NORTH FALLS OFFSHORE WIND FARM DEVELOPMENT CONSENT ORDER

PINS REFERENCE EN010119

**DEADLINE 7: PORT OF LONDON
AUTHORITY'S COMMENTS ON SUBMISSIONS
RECEIVED AT DEADLINE 6**

Deep Water Route Cable Installation Areas (Future Dredging Depths) Plan

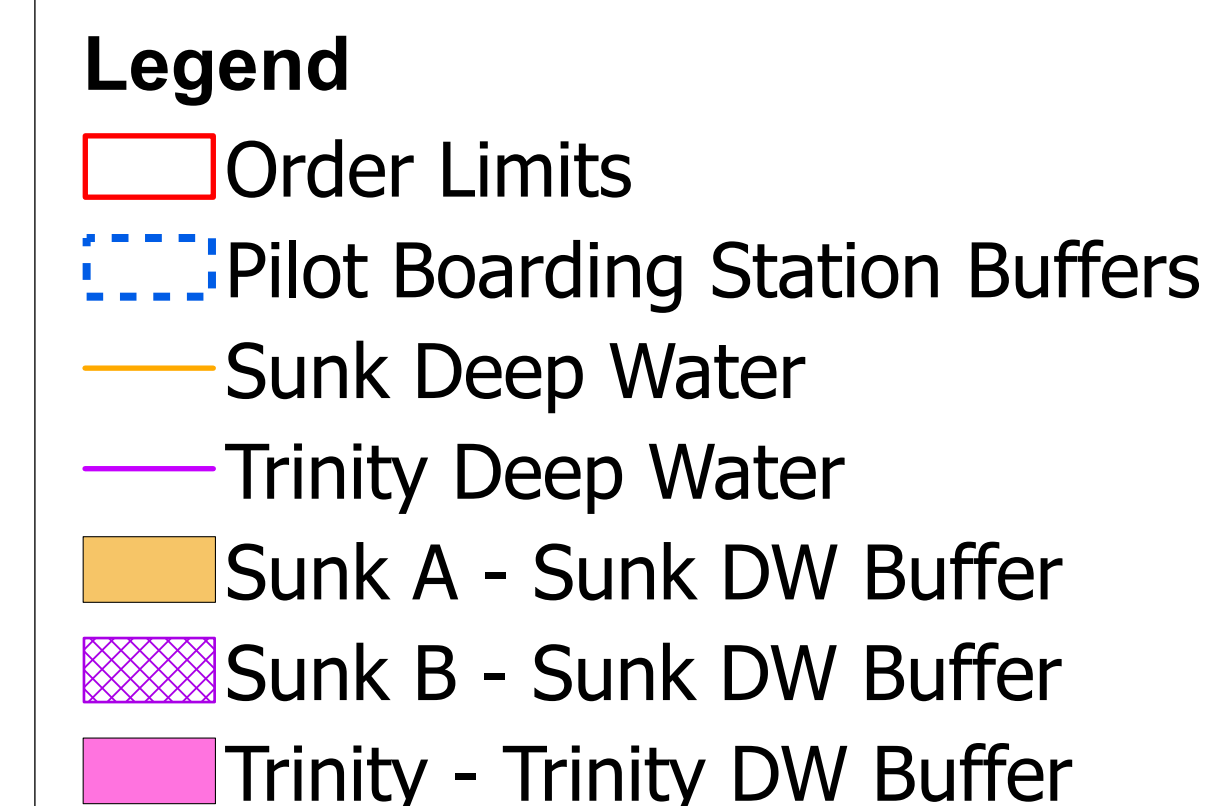
(3) Any part of Work No. 3 and any associated development located within the following areas shown on the Deep Water Route Cable Installation Area (Future Dredging Depths) Plan, must be designed, installed, operated and maintained at a level which would not preclude or impede dredging:

- (a) of the area shown shaded in orange and labelled Sunk A – Sunk DW Buffer, to a level of 22 metres below Chart Datum;
- (b) of the area shown shaded in pink and labelled Trinity – Trinity DW Buffer, to a level of 22 metres below Chart Datum; ~~and~~
- (c) ~~to of~~ the area shown ~~cross-hatched purple~~ shaded in green and labelled Sunk B – Sunk DW Buffer, to a level of 19 metres below Chart Datum; ~~and~~
- (d) of the area shown shaded in blue and labelled Sunk Pilotage Area – Sunk Pilot Diamond Buffer, to a level of 22 metres below Chart Datum.

(3) In undertaking activities under paragraphs (2)(a), (2)(d), (2)(e) and (2)(f), other than in areas shown shaded orange, pink ~~or hatched purple~~, green or blue on the Deep Water Route Cable Installation Area (Future Dredging Depths) Plan where navigable depth may not be reduced to any extent, the undertaker must not reduce water depth by more than 5% Chart Datum unless agreed with the MMO and the MCA in writing.

The PLA welcomes the change to add paragraph 2(d) and can confirm that the colour reference updates are correct.

Figure 2-1 – Onshore Works Plans [AS-019] overlaid with communications link LoS

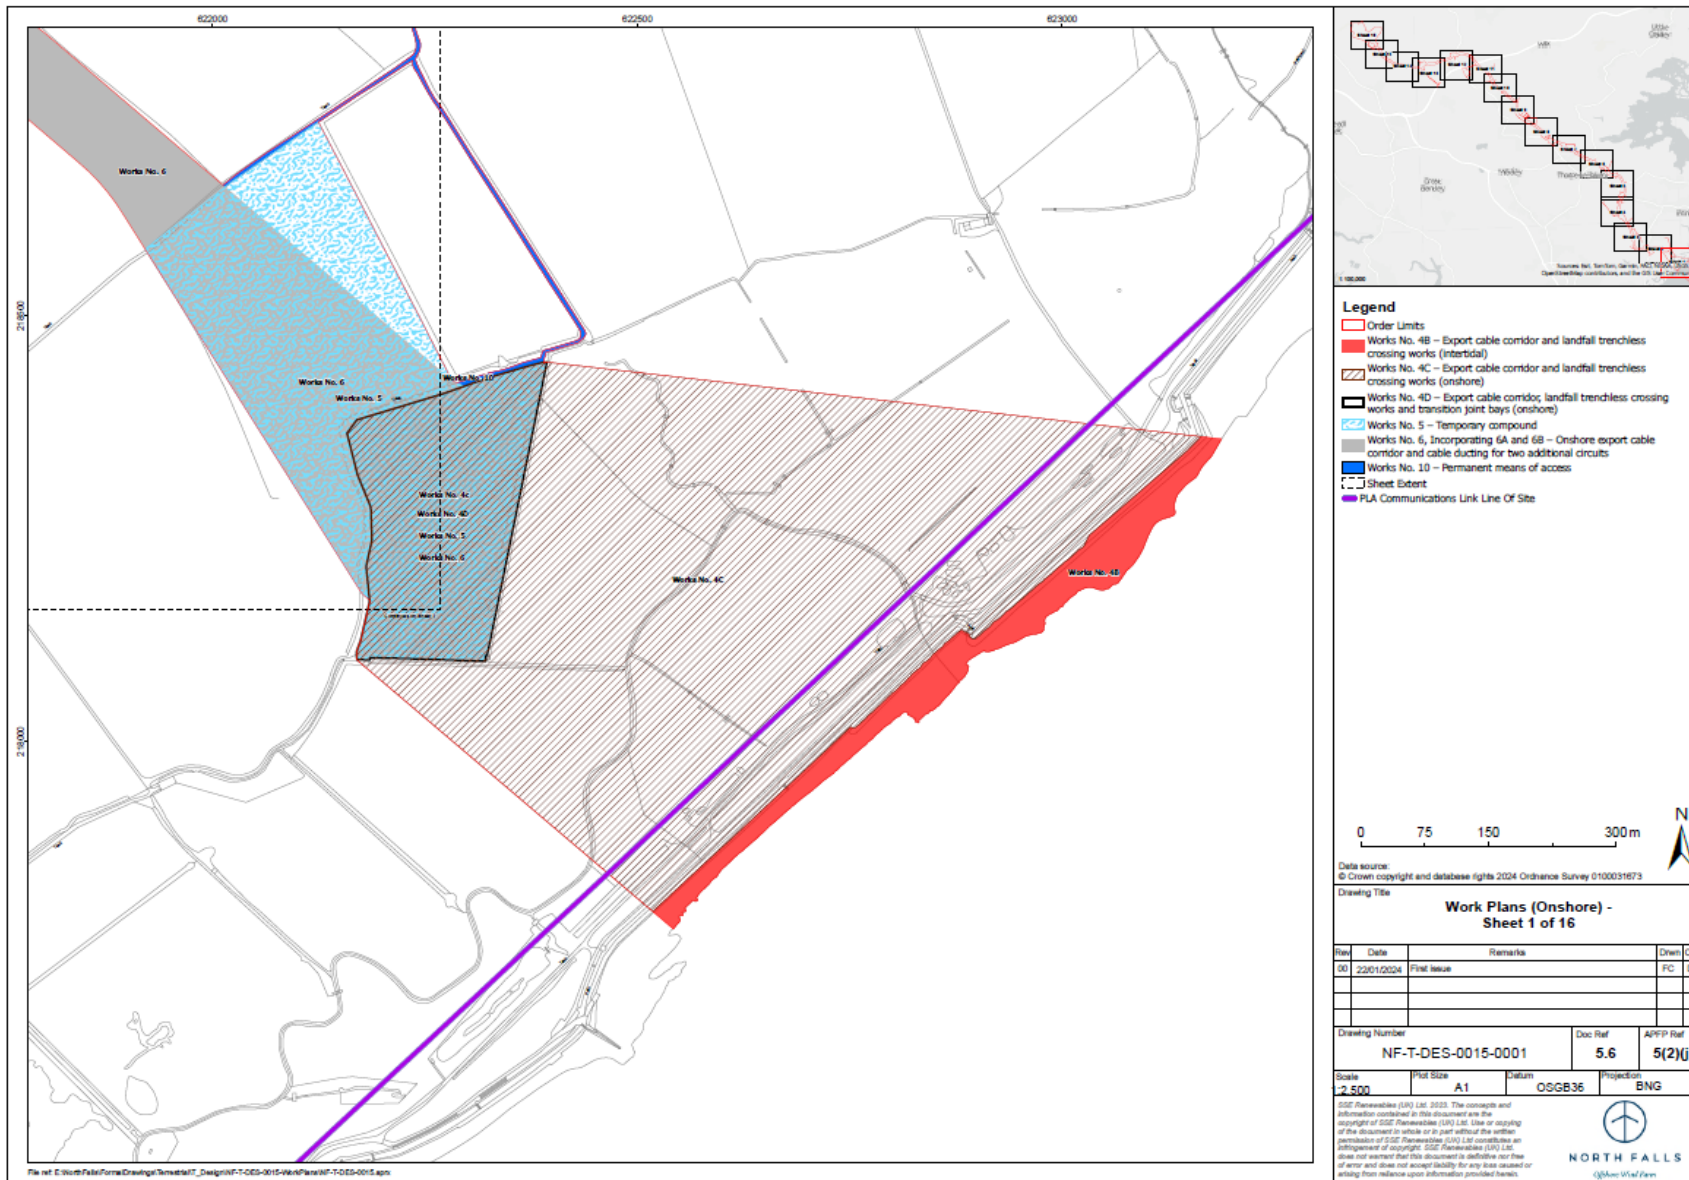
2.1 The PLA welcomes the dialogue with the Applicant and technical note that was produced at deadline 6 [REP6-067] which demonstrates that there is no impact on the PLA's Holland Haven to Walton Pier radio link. The PLA considers this matter resolved and has no further comments on this matter.

- Order Limits
- Sheet Boundary
- Deeper Areas of Burial Node (Point)
- Sunk Deep Water Route 500m Buffer
- Sunk Deep Water Route 700m Buffer
- Trinity Deep Water Route Buffer
- Sunk Pilot Diamond Buffer

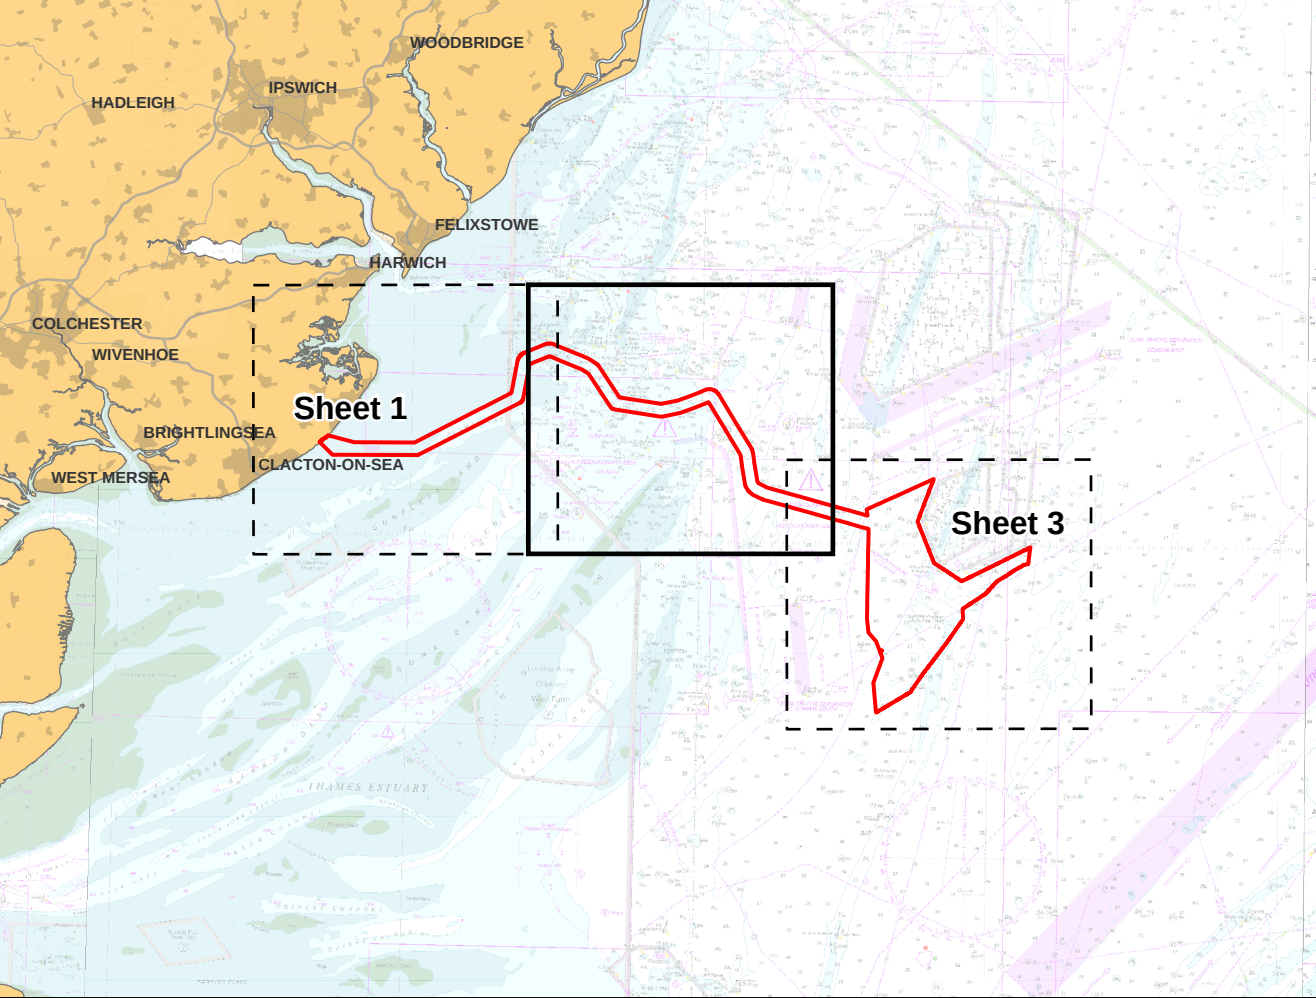
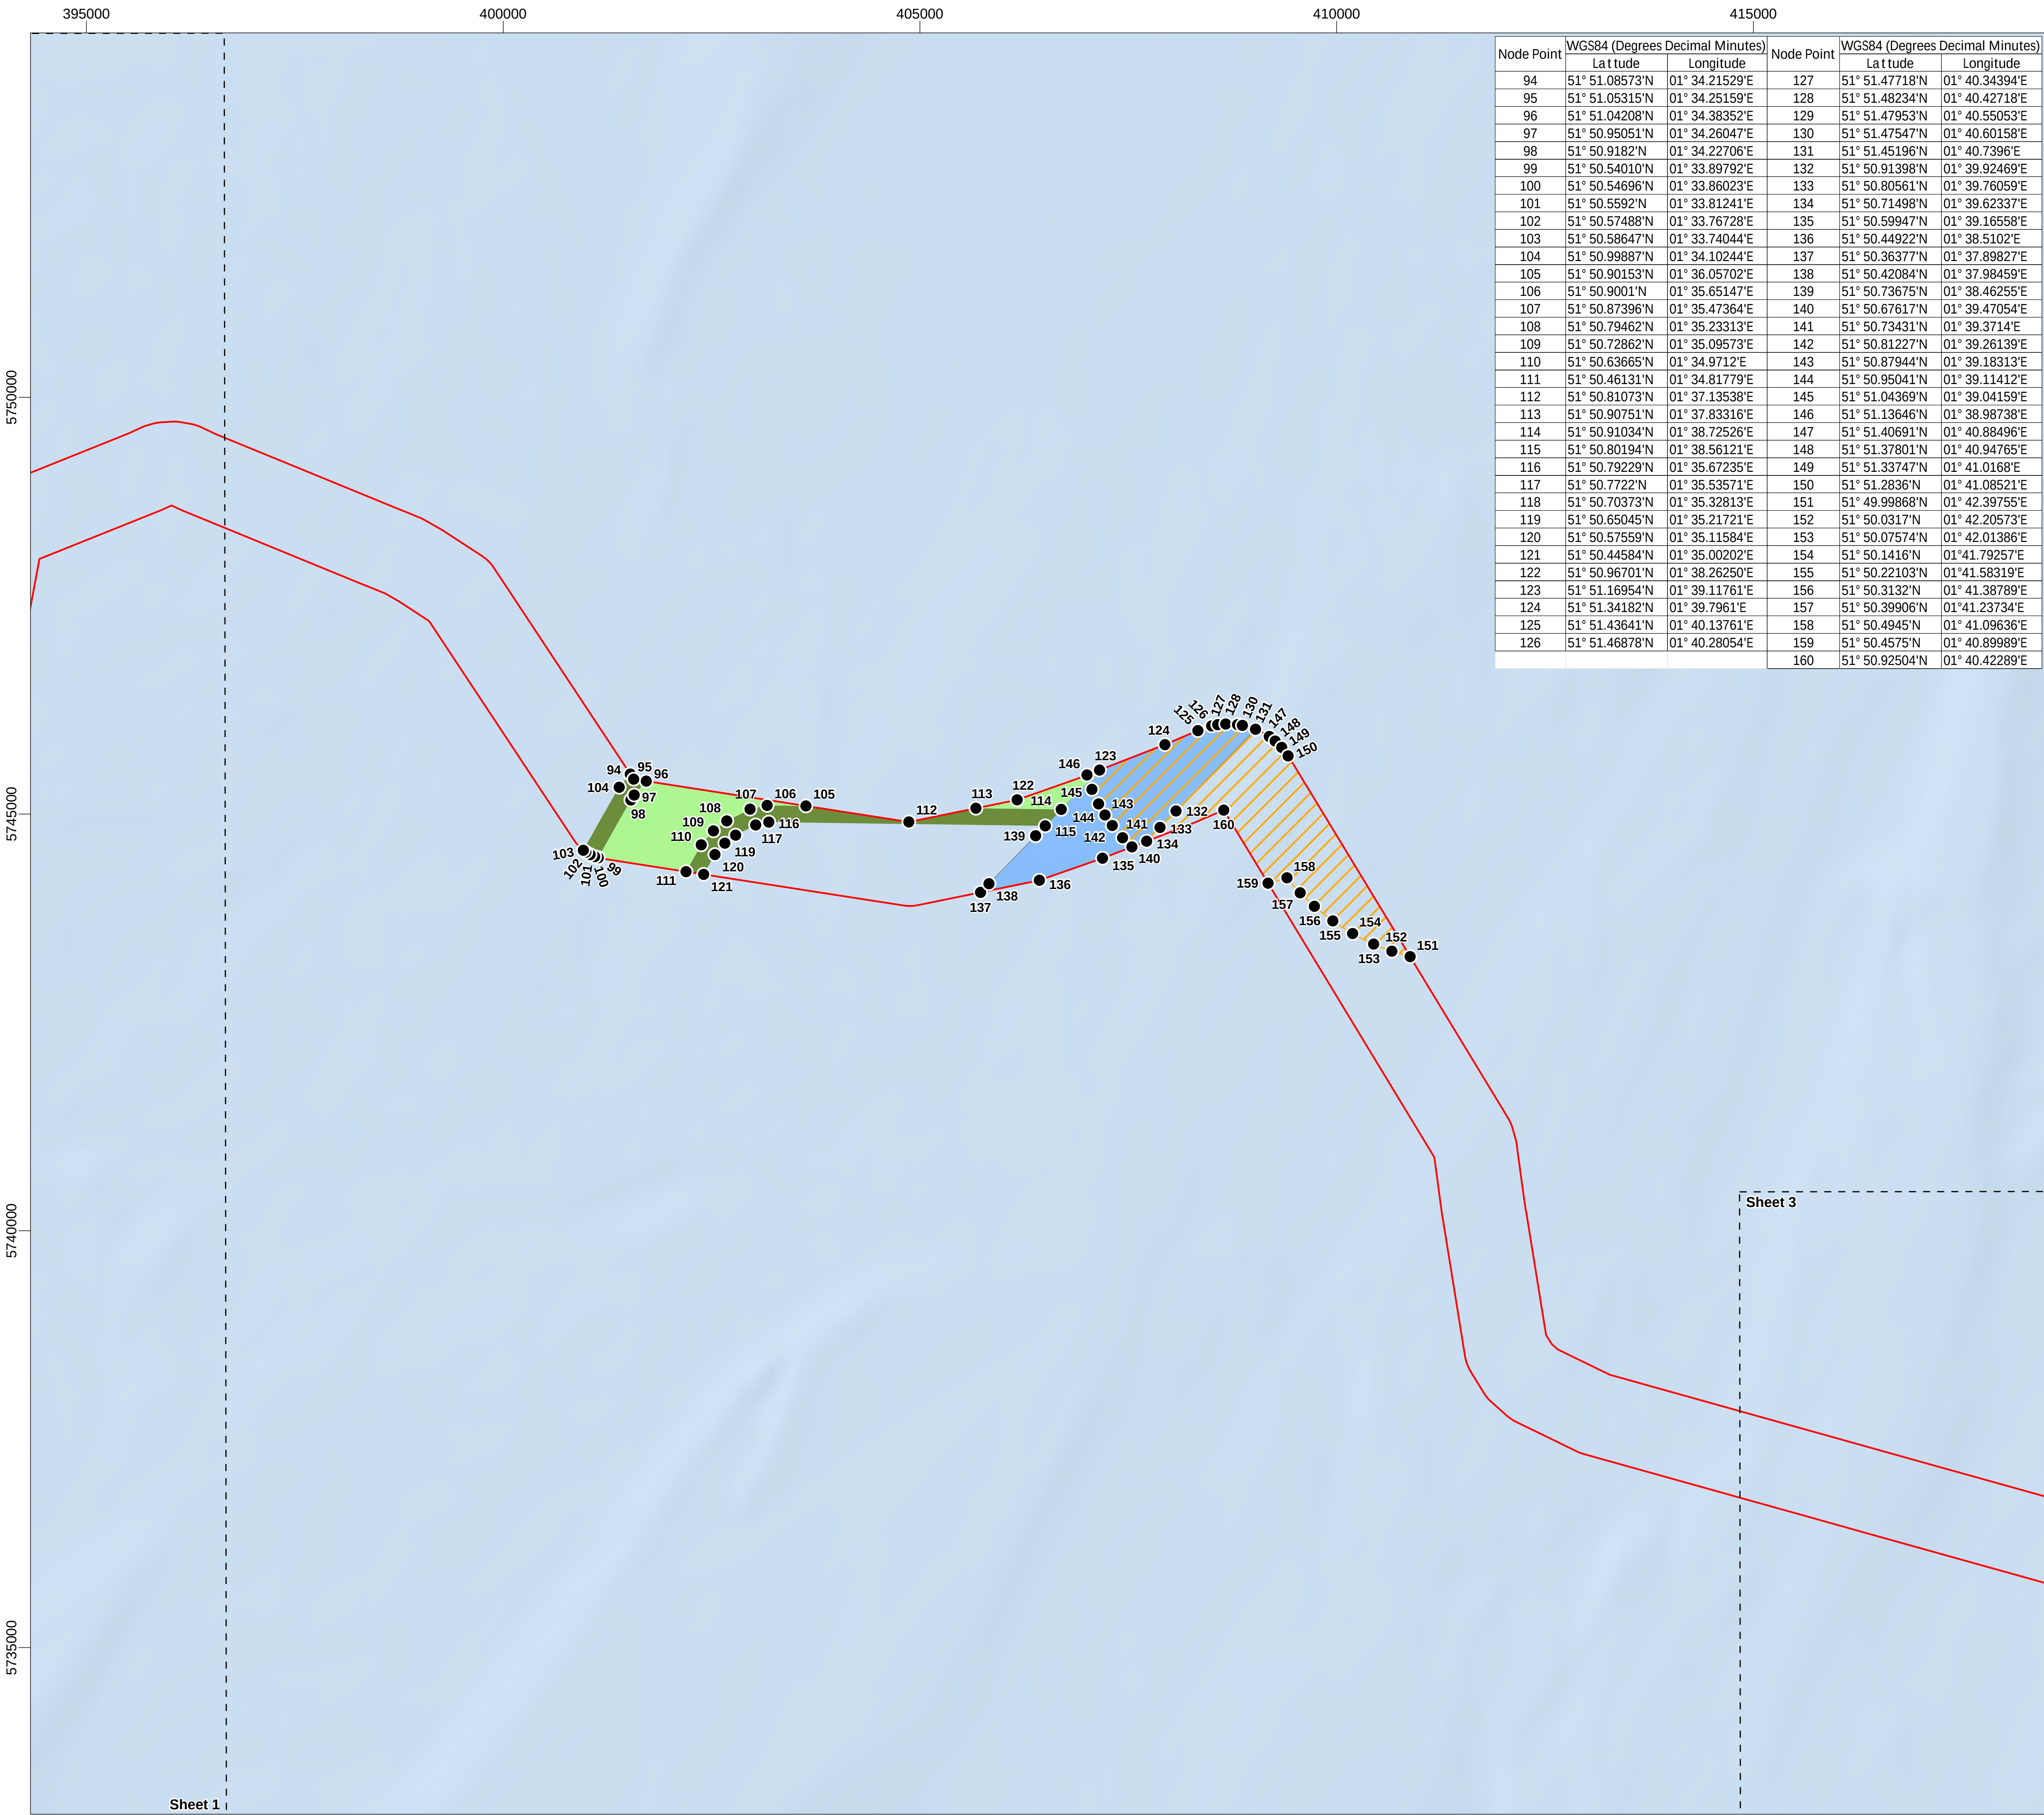
3.1 Sheet 2B was included in the Offshore Order Limits and Boundary Co-ordinates Plan [REP6-004] at deadline 6. This provides co-ordinates for the Sunk (500m and 700m) and Trinity Deep Water Route Buffers and a new Sunk Pilot Diamond Buffer. The Deep Water Route Plan [REP6-055] has also been updated.

3.2 The PLA had recommended in its deadline 5 response [REP5-111] an extension to the deep water area at the top of the Trinity/Sunk diamond with the majority of it at -22m CD and the buffer to the south at -19m CD. Whilst the Applicant has presented the PLA's requirement in a different way (through the inclusion of a Sunk Pilotage Area – Sunk Pilot Diamond in addition to an extension of Sunk A and Sunk B) the effect is the same in terms of safeguarding water depths. The PLA welcomes the Applicant's engagement with the PLA on this matter.

3.4 As a consequence of the Applicant's different approach, however, there now appear to be slightly different commitments across the various certified documents and the dDCO. This has been discussed with the Applicant and is summarised in table 1 below. The PLA expects the commitments to apply to all areas (Sunk A and B, Trinity and the Sunk Pilotage Area). The
